WEST SUSSEX COUNTY COUNCIL CONSULTATION

TO:	Arun District Council FAO: David Easton
FROM:	Highways, WSCC
DATE:	5/07/2018
LOCATION:	Land west of Brook Lane and South of A259 Angmering
SUBJECT:	A/83/18/RES Approval of reserved matters following outline approval A/44/17/OUT for access only for the demolition of existing buildings on site & the erection of a mixed use development comprising up to 90 No. residential units & a care home (Use Class C2 & C3) & ancillary facilities, including railway crossing, together with associated access, car parking & landscaping. This application also lies within the parishes of Littlehampton & Rustington. This application is a Departure from the Development Plan.
DATE OF SITE VISIT:	N/A
RECOMMENDATION:	☐ Advice ☐ Objection ☐ Modification ☒ No Objection ☐ More Information ☐ Refusal
S106 CONTRIBUTION TOTAL:	N/A

drawing number SPRUST(BROOK LANE).1/10 rev. D

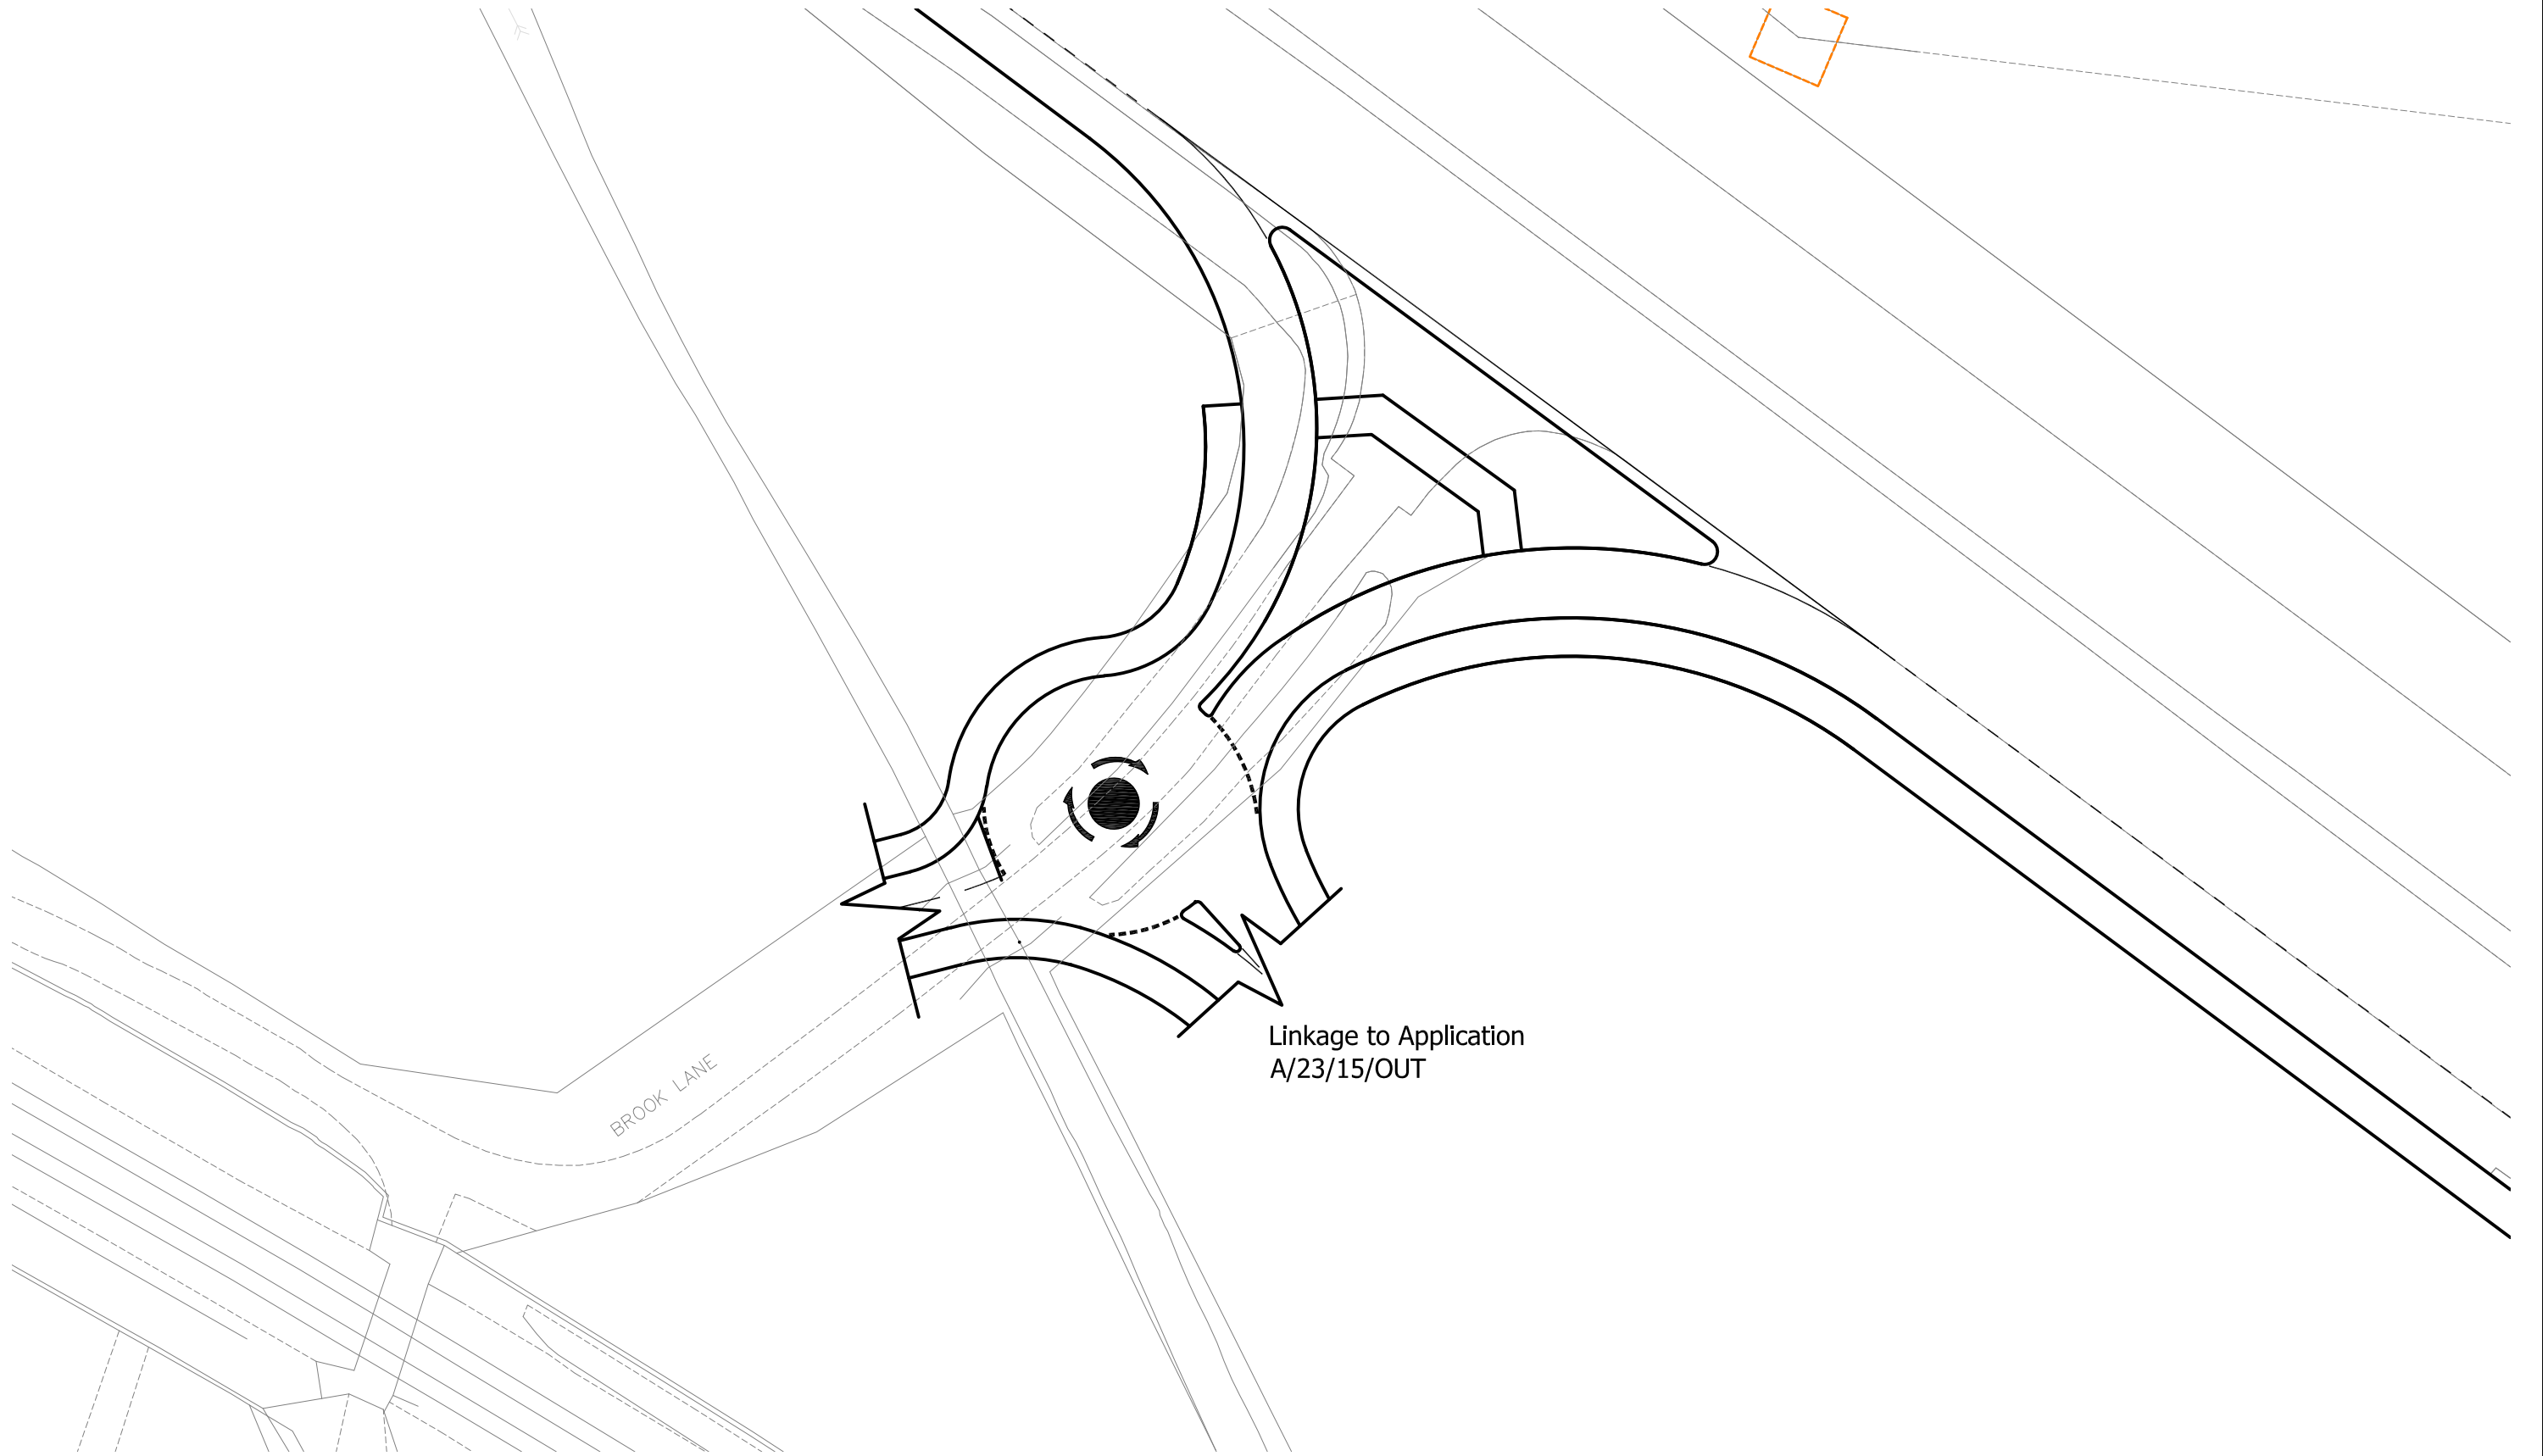
The applicant has undertaken a design review and stated that there are no departures from standard and undertaken a Stage 1 Road Safety Audit and provided a designers response. The applicant has submitted a drawing entitled Possible Linkage to adjacent site (Drawing Number SPRUST(BROOK LANE) 1/10) which demonstrates that a potential connection can be provided to the adjacent site (application A/23/15/OUT) which Arun Planning Committee were minded to approve at the May committee. This therefore demonstrates that the proposed access does not preclude the application (A/23/15/OUT), which is minded to approve, from coming forward; subject to agreement of rights of access which are private non planning matters. Given that the applicant has demonstrated that the adjacent scheme which is minded to grant (A/23/15/OUT) can still be accessed and that this application does not preclude the consented scheme from coming forward the Highway Authority would not object to this application.

A condition should be included on any permission granted that states the access should be provided prior to first occupation of the development and the following informative included on any permission granted.
